SAVE MIRFIELD

**LAND EAST OF WOODWARD COURT, MIRFIELD
OBJECTIONS TO PROPOSED RESIDENTIAL DEVELOPMENT
BY BELLWAY HOMES ON HIGHWAY GROUNDS**

February 2026

- 1.1.1 Save Mirfield object to the planning application for a residential development of 75 dwellings on land east of Woodward Court, Mirfield by Bellway Homes (LPA Ref: 2025/93355) as the proposed development would have an **unacceptable impact on road safety** throughout the local area. The main site access is on Woodward Court, with egress onto Hepworth Lane, for left turning traffic also proposed. The proposed site access arrangements are considered unsatisfactory and traffic generated by the proposed development would unacceptably affect safety and operation of the local highway network.

Image 3.3 Proposed Woodward Court/Wellhouse Lane Improvements

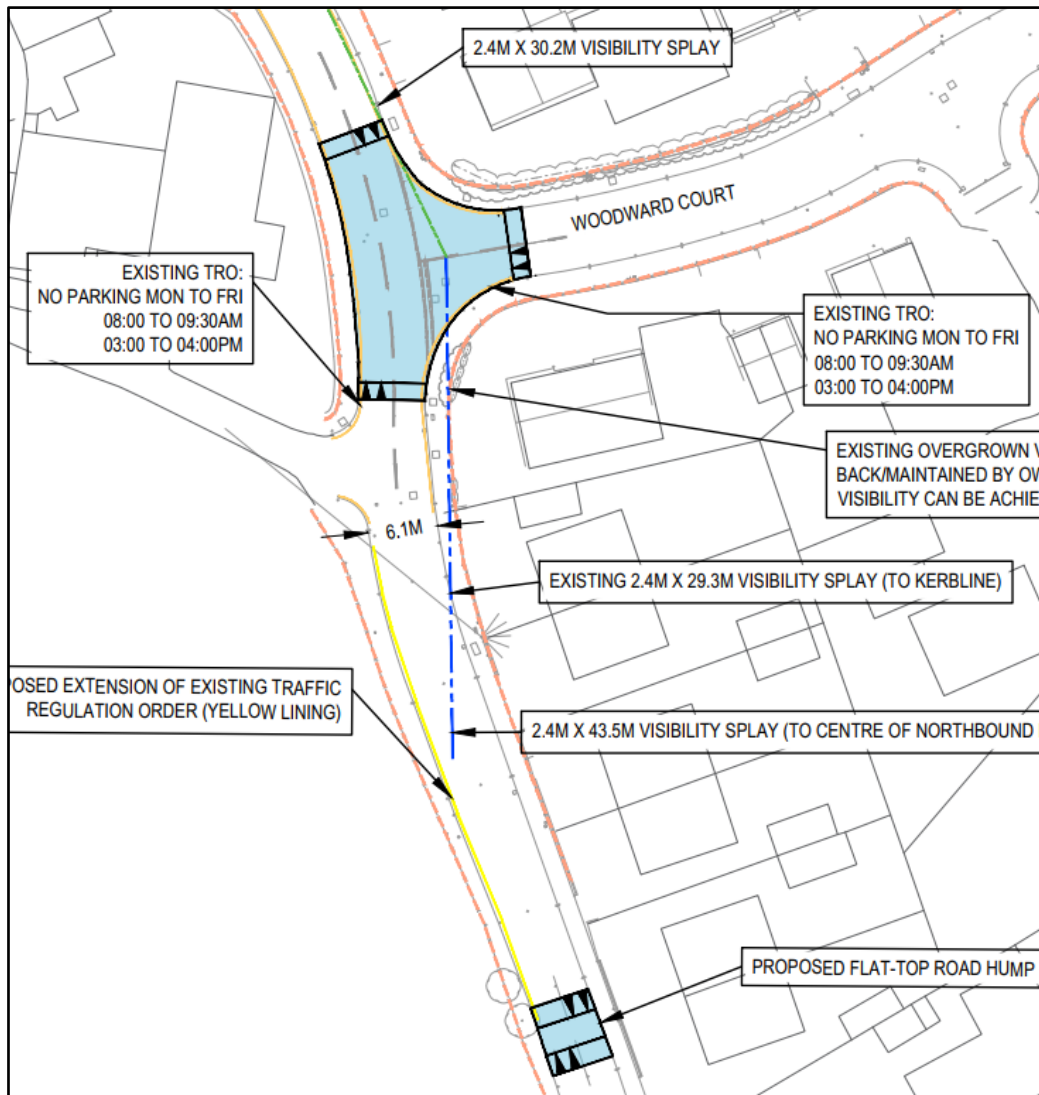
1.5.2 The traffic calming measures seek to reduce the speed of traffic on Wellhouse Lane approaching the junction with Woodward Court to a level at which the visibility available is sufficient. **A Road Safety Audit of the mitigation proposals has however not been undertaken and is required.** The mitigation measures as now proposed are however considered unsatisfactory on road safety grounds due to the excessive distance (130 metres) between the raised table at the junction of Wellhouse Lane and Woodward Court and the road hump on Wellhouse Lane, to the north of the Crossley Fields school access.

1.5.3 Government guidance¹ indicates a spacing of 60 to 90 metres between traffic calming features, is desirable and that spacings of more than 100 metres may give rise to increased speeds between the traffic calming measures (with vehicles accelerating away from one traffic calming feature and braking when approaching the next). **The potential for the increased traffic speeds on the Crossley Fields school frontage is considered unacceptable from a road safety viewpoint.**

Image 3.4 Proposed Hepworth Lane Site Egress

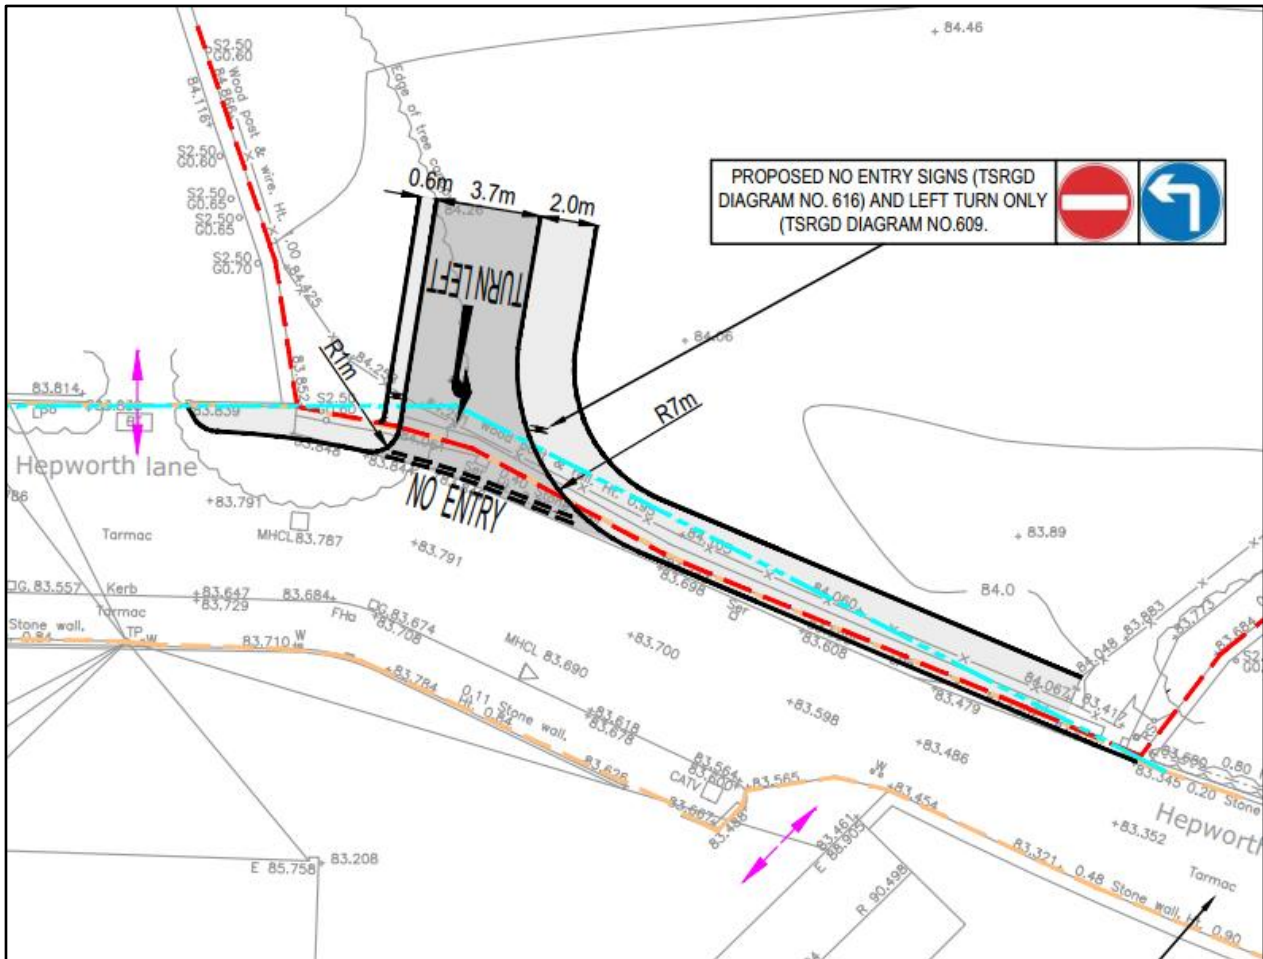
1.4.4 The submitted Transport Assessment confirms that a **‘measurable increase in traffic’** would result throughout the local area, which from the Council’s own assessment would be **unacceptable from a road safety viewpoint**. The locations of particular concern listed in paragraph 1.4.2 above and include Woodward Court, Wellhouse Lane and Hepworth Lane. The proposed egress onto Hepworth Lane is also considered unacceptable on road safety grounds as in addition to the stated inadequacies of Hepworth Lane, safe and satisfactory operation of the egress would be prejudiced by on-street parking nearby.

1.8.1 The proposed development of 75 dwellings would give rise to **unacceptable impacts on road safety throughout the local area**. Woodward Court is not suitable for access due to on-street parking and pedestrian vehicle conflict at the beginning and end of the school day. The proposed egress onto Hepworth Lane is also unacceptable on road safety grounds as operation would be prejudiced by restricted road width and on-street parking nearby.

## **Appendix H Proposed Woodward Court Site Access & Wellhouse Lane Improvements (Optima Drawing.25033/GA/02)**

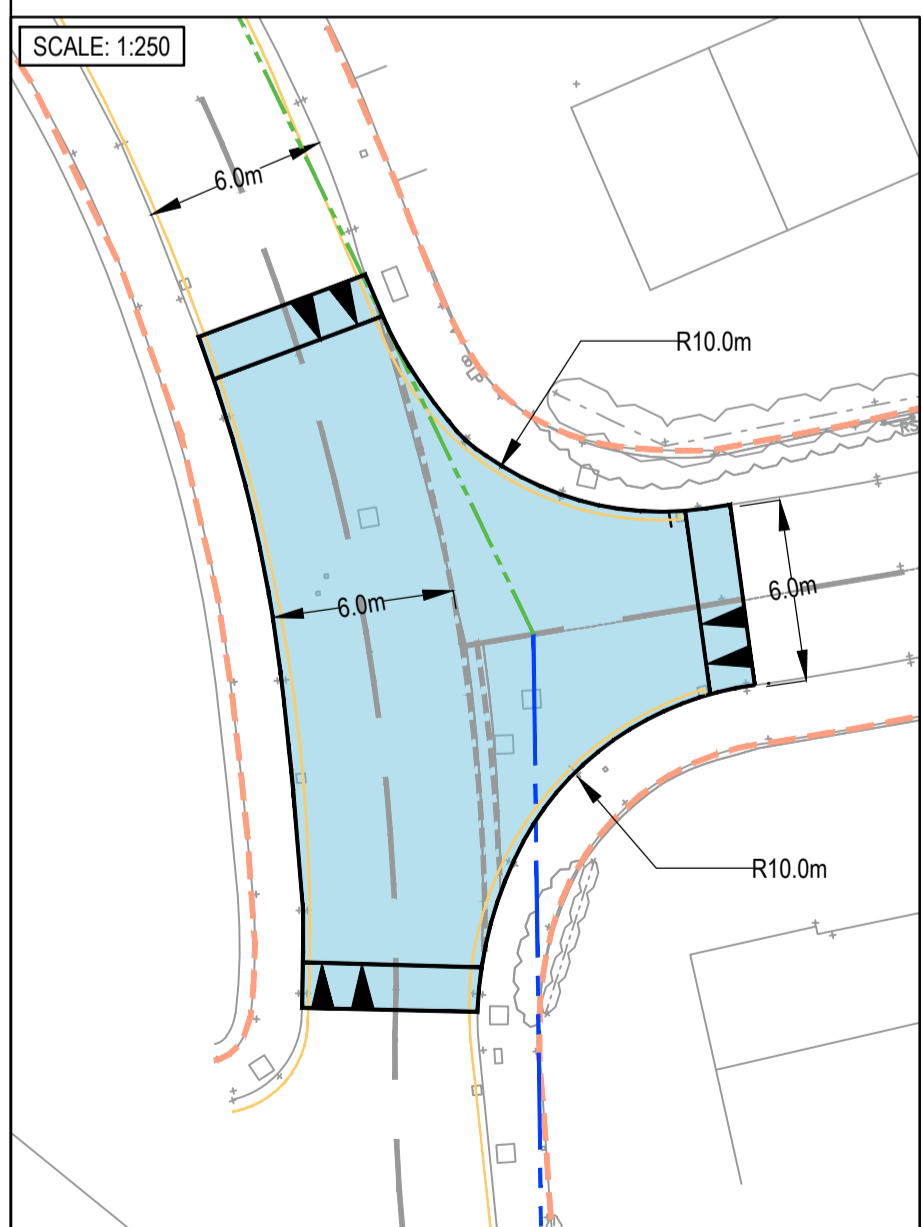
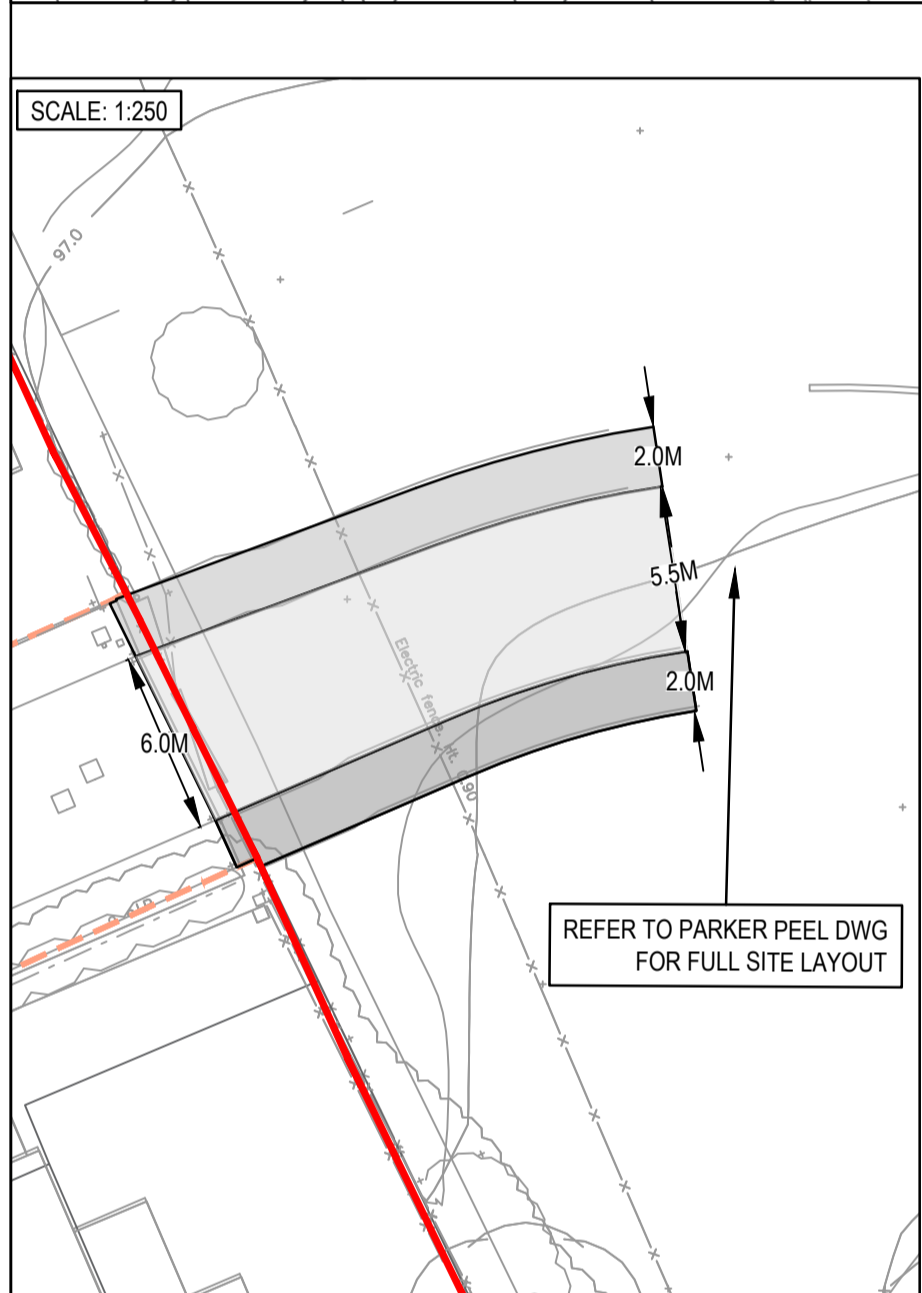
1.5.1 The application seeks to address the visibility issue at the junction of Woodward Court and Wellhouse Lane through provision of traffic calming measures which are set out below, with additional waiting restrictions also proposed on Wellhouse Lane:

- A raised table at the junction of Woodward Court and Wellhouse Lane;
- A flat-top road hump on Wellhouse Lane, 55 metres south of Woodward Court;
- A flat-top road hump on Wellhouse Lane, 130 metres north of Woodward Court (and approximately 35 metres north of the school access)

1.8.2 Visibility to the left at the junction of Wellhouse Lane and Woodward Court is sub-standard with the intensification of use arising from the proposed development resulting in increased risk of collision. Whilst the applicant has identified traffic calming measures with a view to mitigating this issue, the proposed traffic calming scheme is considered unacceptable as based on Government guidance the proposals may result in increased traffic speeds on the Crossley Fields school frontage.
